# CITY OF ALBUQUERQUE

**Re: Bosque Plaza – Guardian Storage**  
**3600 Bosque Plaza Lane NW**  
**30-Day Temporary Certificate of Occupancy**  
**Transportation Development Final Inspection**  
Engineer's/Architect's Stamp dated 2-22-18 (E12D006E)  
Certification dated 10-3-19

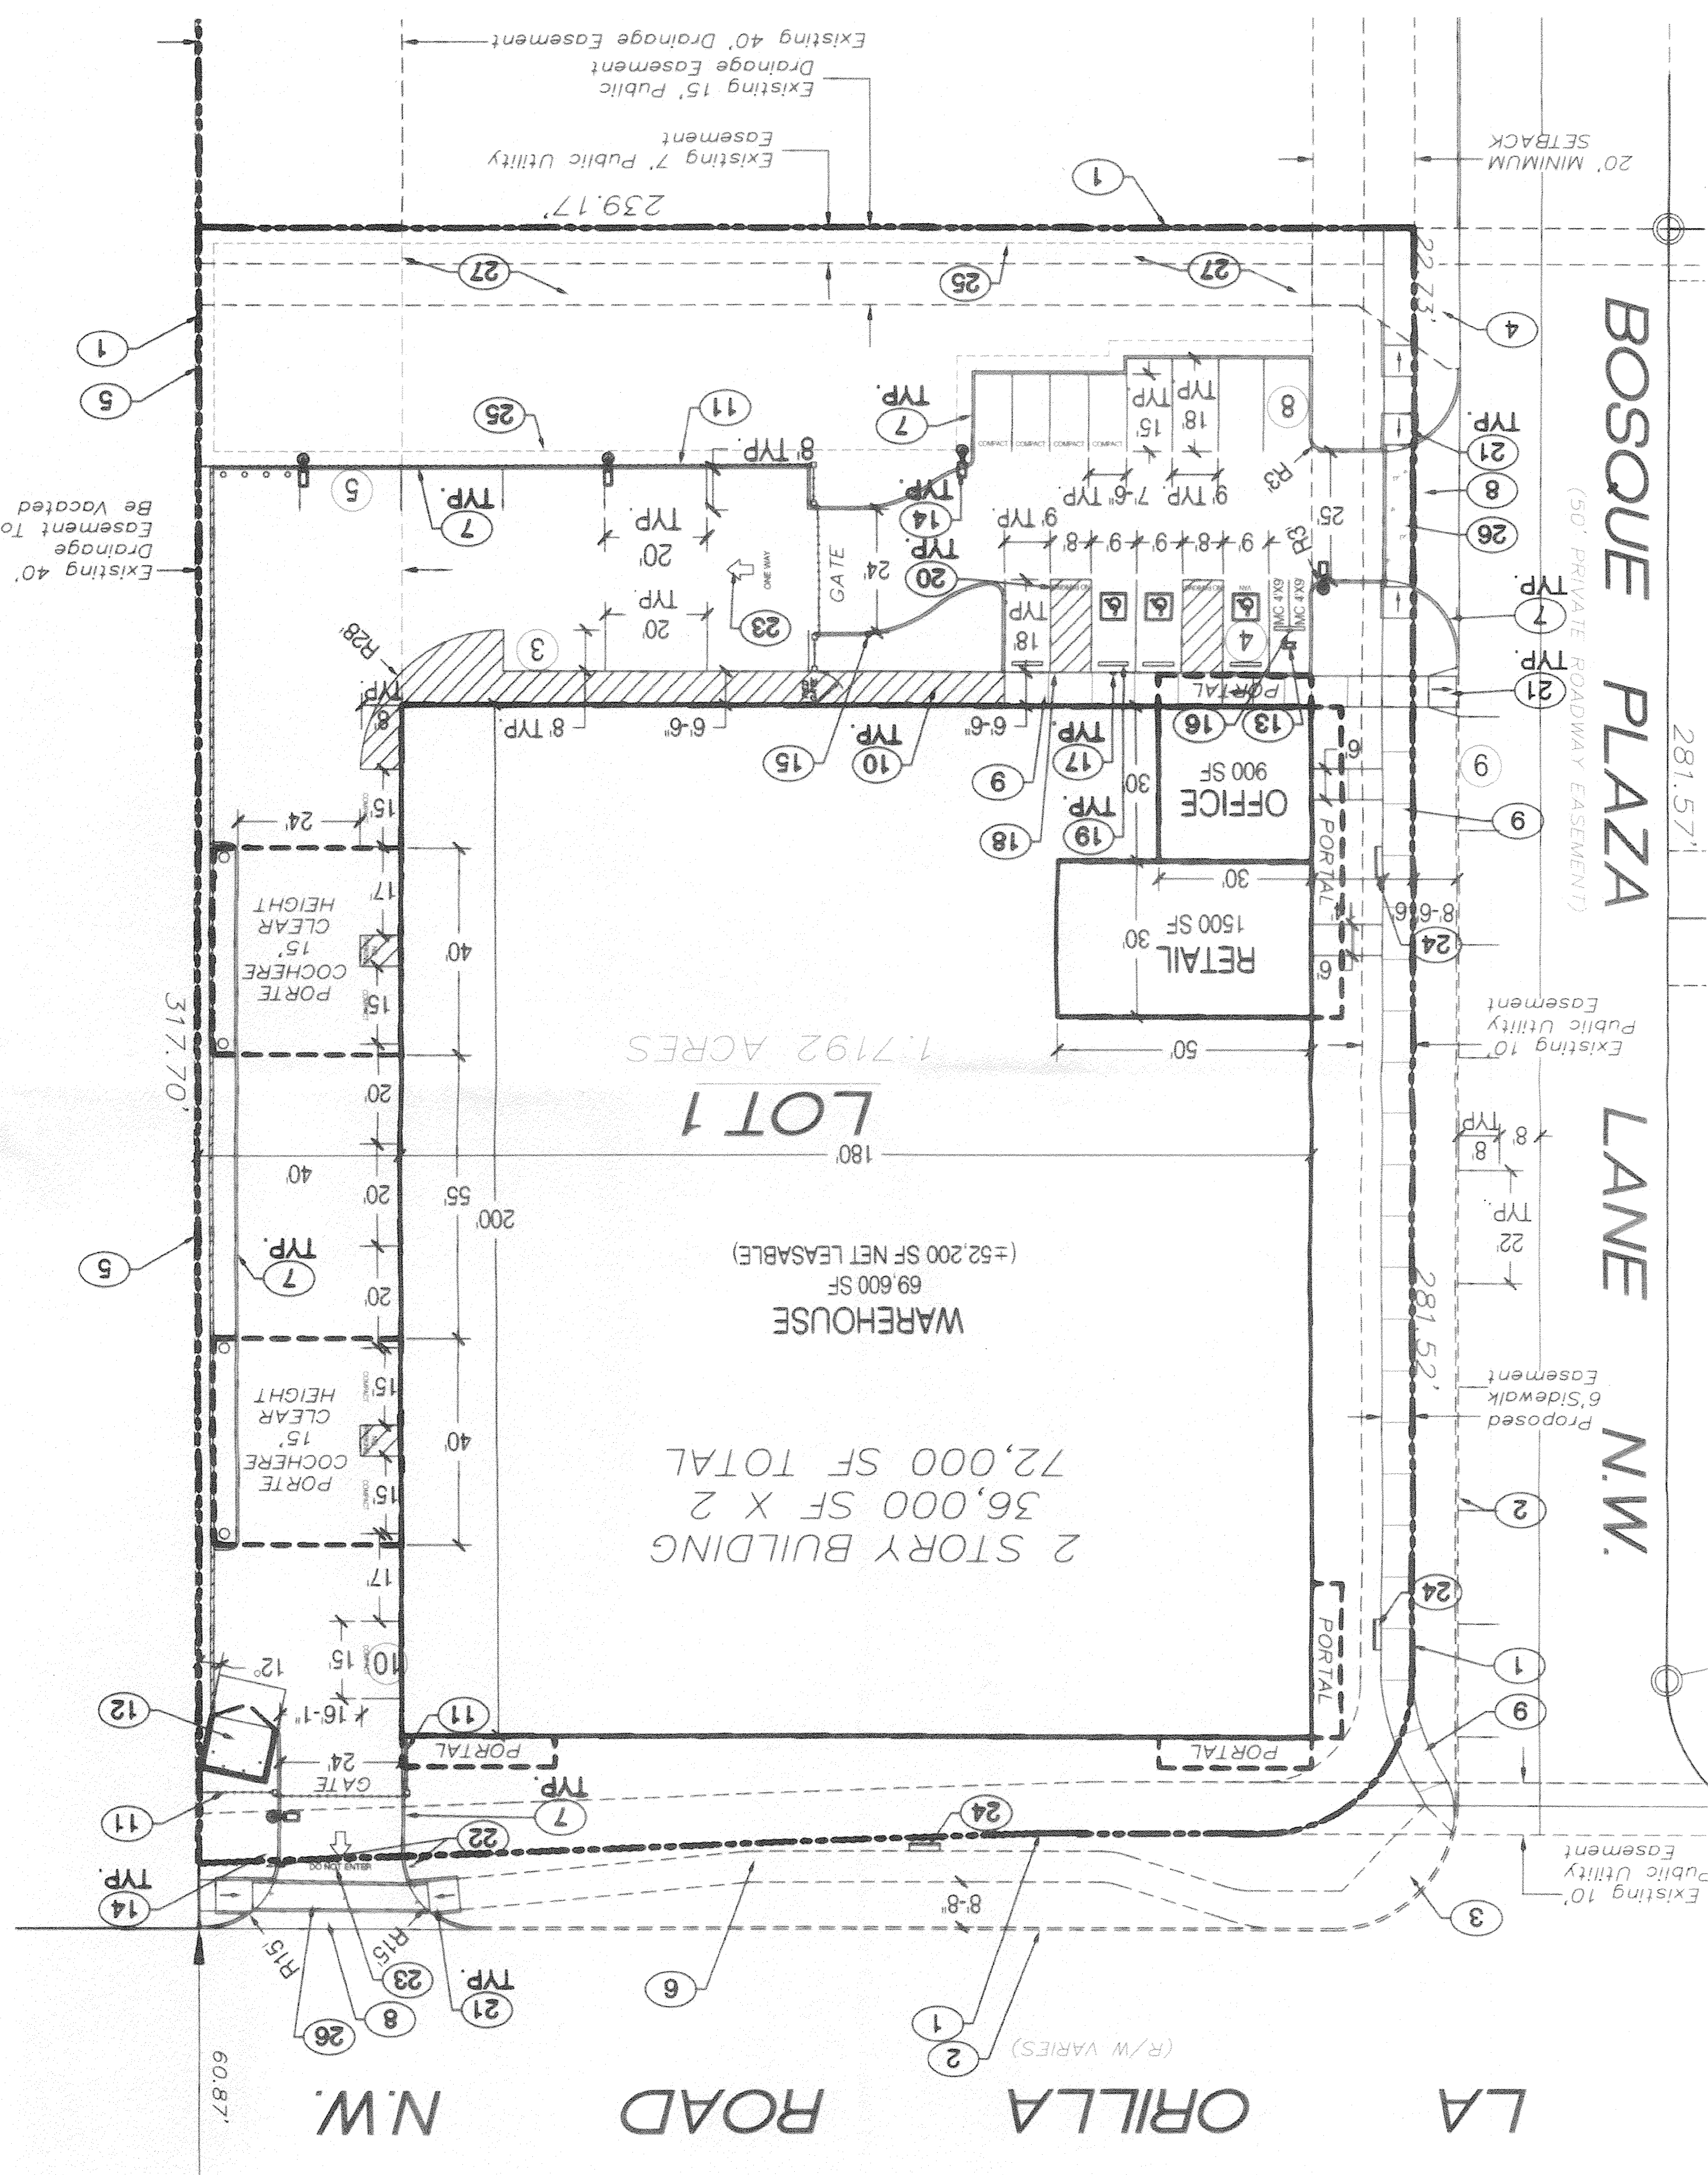
- Please submit an (AA) Administrative Amendment to Urban Design & Development section reflecting the reconfiguration of the parking stalls. Please contact Russell Brito @ (505)924-3337 for questions.

- Please add missing parking bumpers to the ADA stalls.
- ADA parking stall signs need to be a minimum of 60 inches off ground so that they are visible while vehicles are parked in a space.

- Please add Motorcycle Signs. (Motorcycle parking spaces shall be designated by its own conspicuously posted upright sign, either free-standing or wall mounted per the IDO. Each stall requires its own sign)
